Application for a Non-Material Amendment Following a Grant of Planning Permission

Construction of a ground floor single storey side/rear infill extension and first floor rear extension to end of outrigger.

23/AP/2236

DATE: Nov 2023	DRAWING NO: 23/ 058	SHEET NO: P4B
--------------------------	-------------------------------	-------------------------

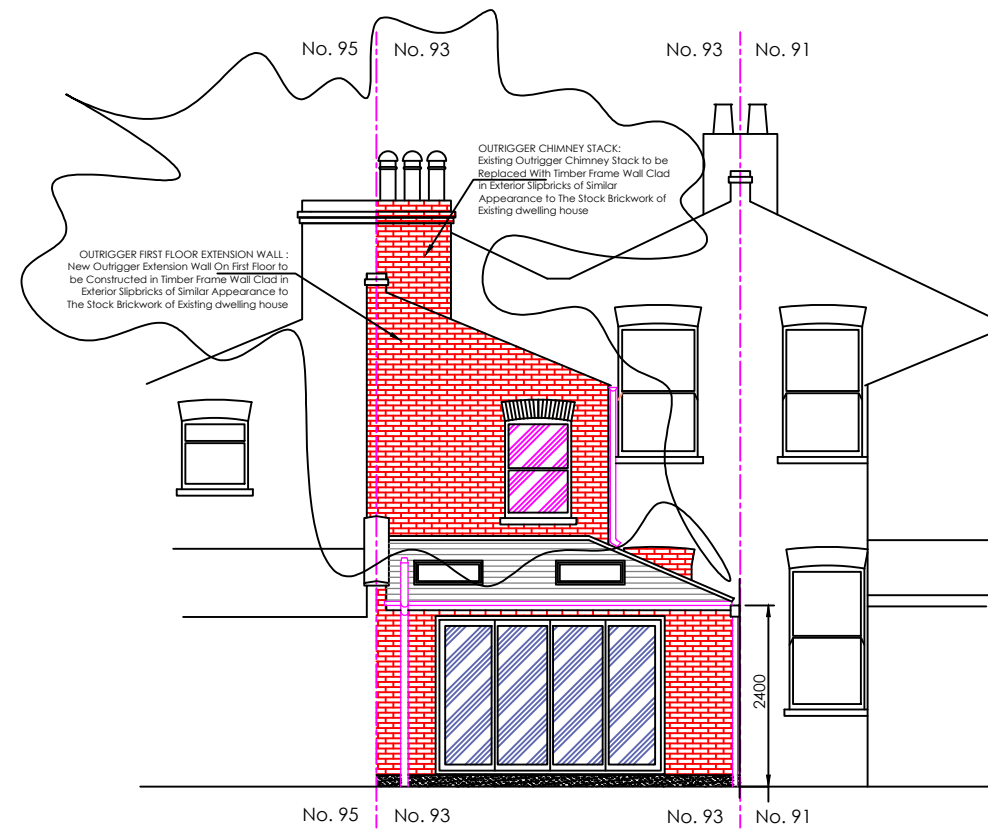
Existing Outrigger Wall And Chimney Breast On First Floor to be Replaced With Timber Frame Wall Clad in Exterior Slipbricks of Similar Appearance to The Stock Brickwork of Existing dwelling house.

It is safer method of construction and result in better finish and appearance to match the existing London stock brickwork.
